Department of Primary Industries

OUT14/35922

Wambo Coal Mine (DA 305-7-2003 Mod 14) Proposed Modification

Wambo Coal Mine (DA 305-7-2003 Mod 14) Proposed Modification Additional Comment NSW Office of Water - Groundwater Impacts

Figure 10: Predicted subsided surface levels due to Modified Layout

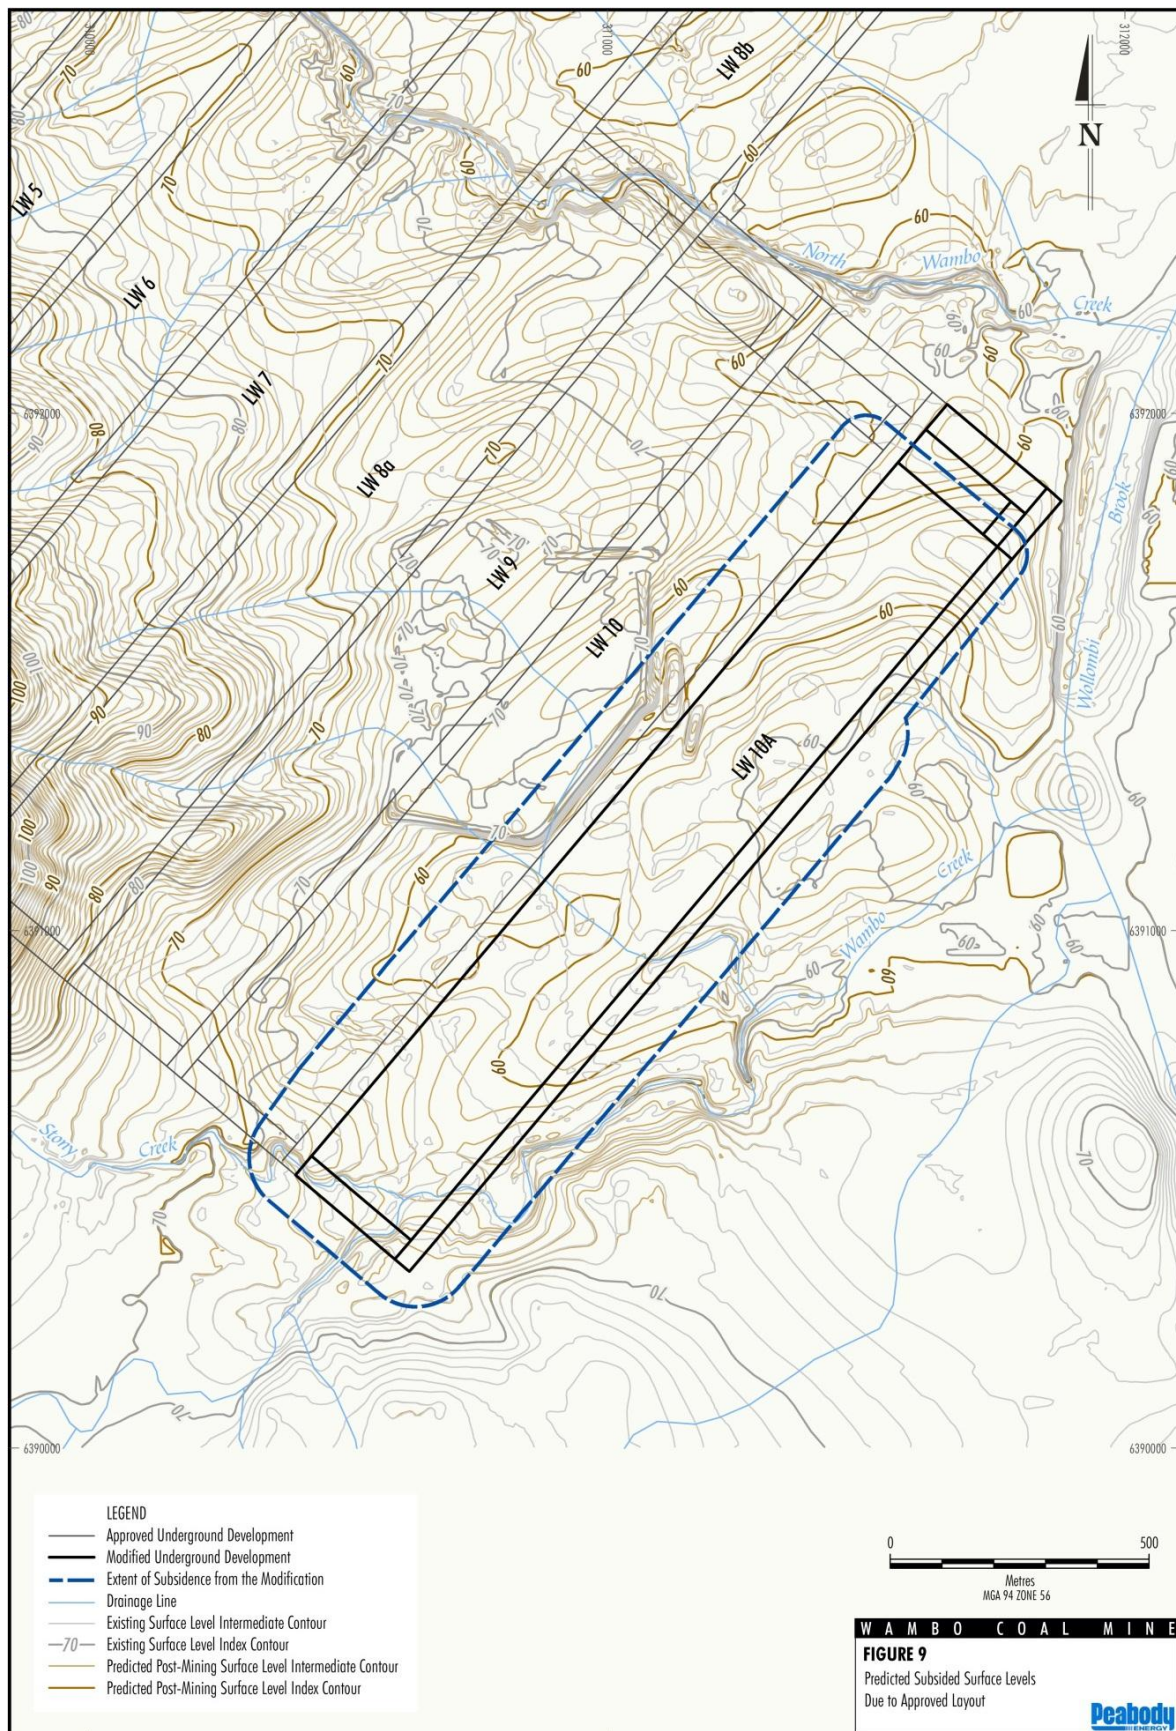
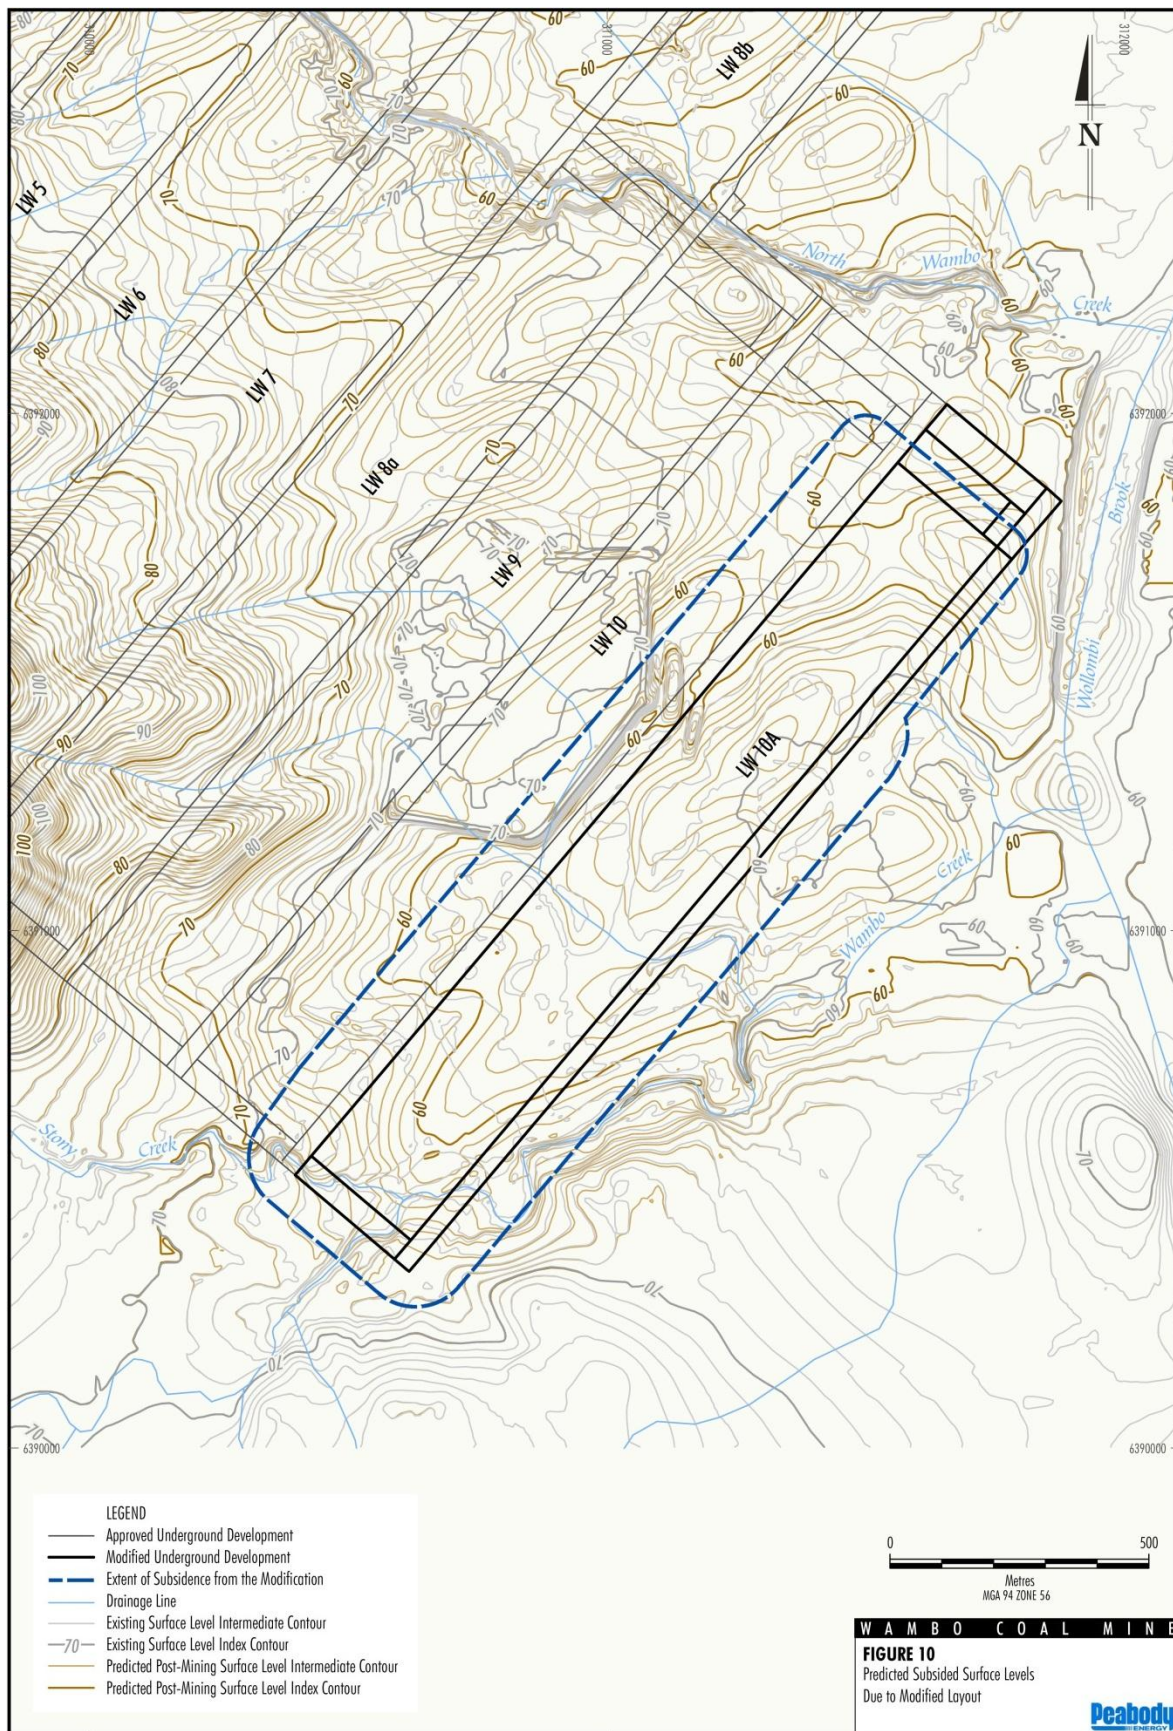
Cumulative subsidence is expected to exceed 4.2 metres to the combined Whybrow and Wambo Seam extraction, and increase to over 7.5 metres total subsidence after the lower seams are taken. This represents a significant risk of further incision and expansion of the channel. However, it is mitigated to some extent by the enlargement of the channel capacity which has already occurred. Remediation of the impacts to both channels resulting from additional, cumulative subsidence is required. This should avoid the use of rip rap and other 'hard' engineered structures in favour of 'flexible' options for rehabilitation. This should incorporate large woody debris works, which should be embedded in the sand bed to below the depth of activation of scour and incision which is likely to occur. This should generally follow:

The use of woody debris or other bed control structures should be reviewed as each seam is extracted. The adjustment of any large woody debris structures should ensure the structures are progressively buried in the watercourse bed, and they fully span the existing channel width, with sufficient keying to both banks to avoid becoming outflanked. Longitudinal bed gradients should be reduced to below 0.15% between the crest to toe of each upstream bed control structure.

Figure 11: Wambo Creek - Existing and Predicted Post Mining Levels and Grades
(Note exaggerated vertical scale)

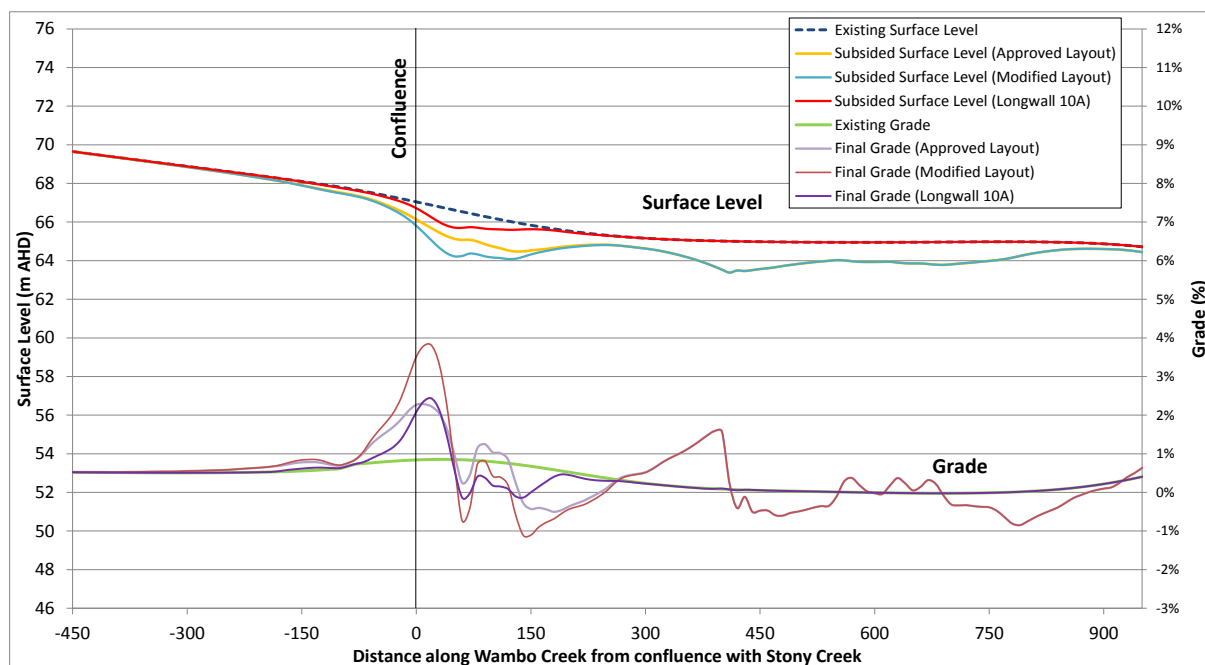
- Provide further assessment and commentary to qualify the conclusions drawn on potential long term salinity within Wambo Creek and associated alluvium. This will need to draw on the following points:
 - the land surface has subsided to a lower elevation,
 - higher Permian pressure heads relative to the alluvium water table (pre mining, mining & post mining),
 - connected fracturing extending across all 4 coal seams and the interburden up to the base of Wambo Creek Alluvium, and
 - small volumes of water gain/loss will make up significant percentages of change to total baseflow and resulting water quality.
- Provide additional assessment of the depth and saturation of the alluvium close to the junction of Wambo and Stony Creeks.
